**Consultation Response from Alan Smith,  
KC Waste Strategy (Refuse & Recycling)**

**2025/91638 The Mansion House, Heaton Lodge, Bog Green Lane, Colne Bridge, Huddersfield,  
HD5 0RF**

**Outline application for erection of residential development (5 dwellings)**

**Responding Ref: WPN 25 026**

Job No. 16 J 28.	Drawing number 10 B	Date May 2025.
---------------------	------------------------	-------------------

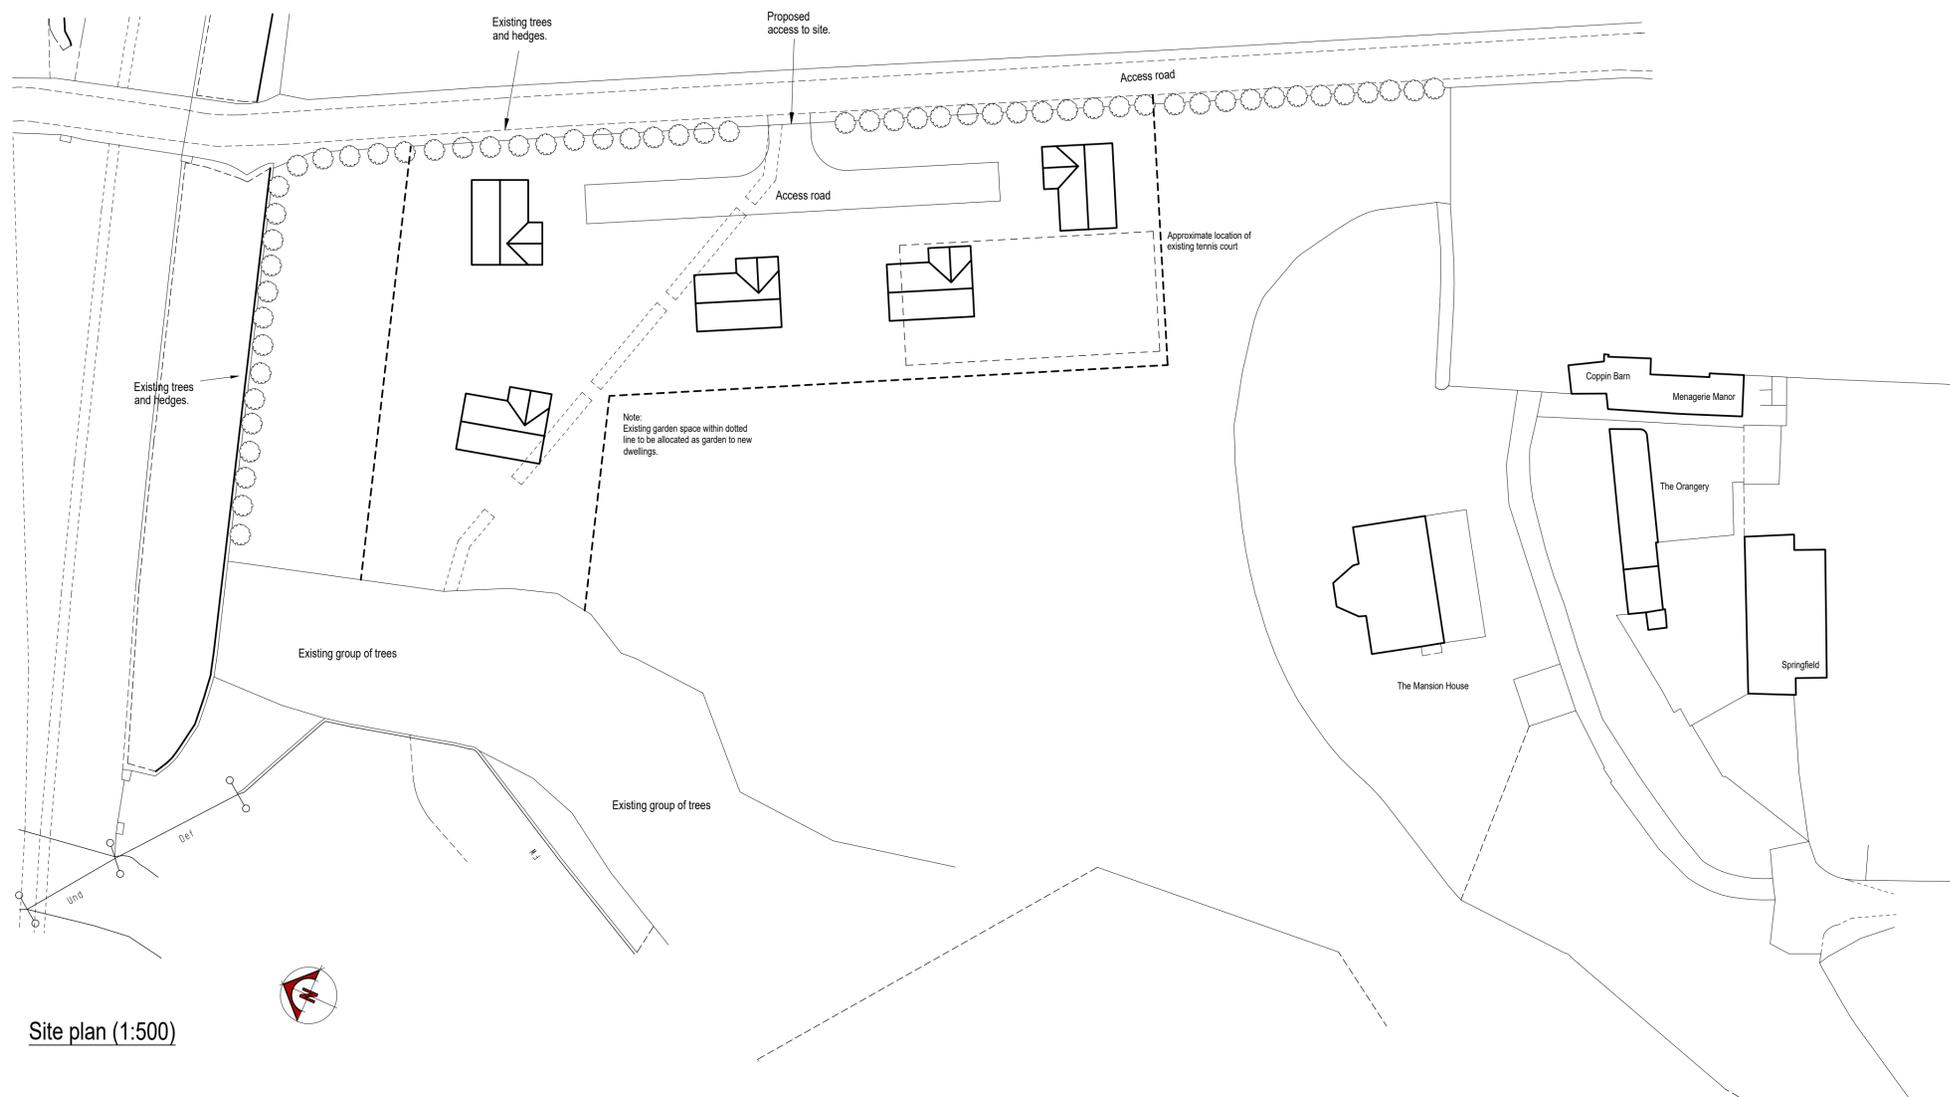
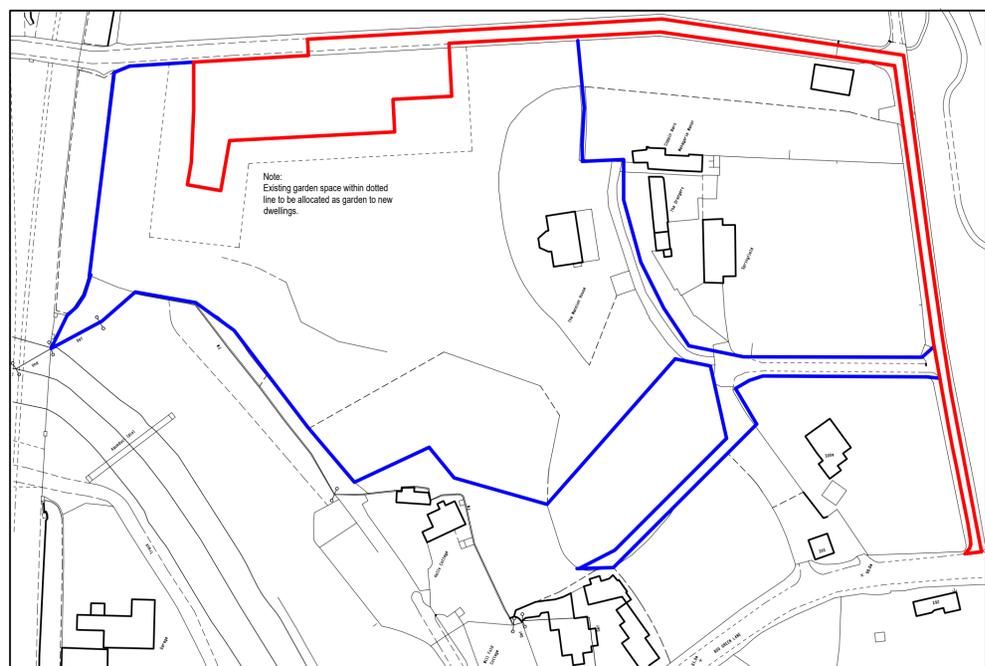
The applicant has submitted the drawing; *“Proposed residential development, Dwg No. 16 J 28, 10B, dated May 2025”*.

- Space will be required for 3 x 240ltr bins at each property, 1 x 240ltr residual waste, 1 x 240ltr recycling and, as the properties have gardens, the space to accommodate a third bin for garden waste or to accommodate future changes to waste collection due to the implementation of Simpler Recycling legislation. The floor space required for each 240ltr wheeled bin is 940mm x 780mm.

- The bin storage should be in the rear gardens, gated access should be shown to be secure, gates wide enough for bins to pass through and the route between the rear gardens and the front access road must not require residents to pull bins up / down gradients of more than 1:12.

- Layout drawings for this development site will need to show a bin collection point (BCP). The BCP should be on a solid surface and where a refuse collection vehicle (RCV) can be easily reached, adjacent to the nearest highway.

- Where turning is necessary, the turning facilities must be demonstrably sufficient for an 11.85m refuse collection vehicle. **Active measures should be taken to prevent parking in the turning head as otherwise an RCV would have a long reverse manoeuvre which is a recognised safety risk and is not acceptable.**

- There is concern that the road down to the new development from Bog Green Lane is unadopted. Elements such as potholes, overgrown trees, flooding, debris, gravel and cracks found in these locations all contribute to damage collection vehicles which are expensive to repair. If an RCV cannot reach the properties a bin collection point closer to Bog Green Lane will be required.
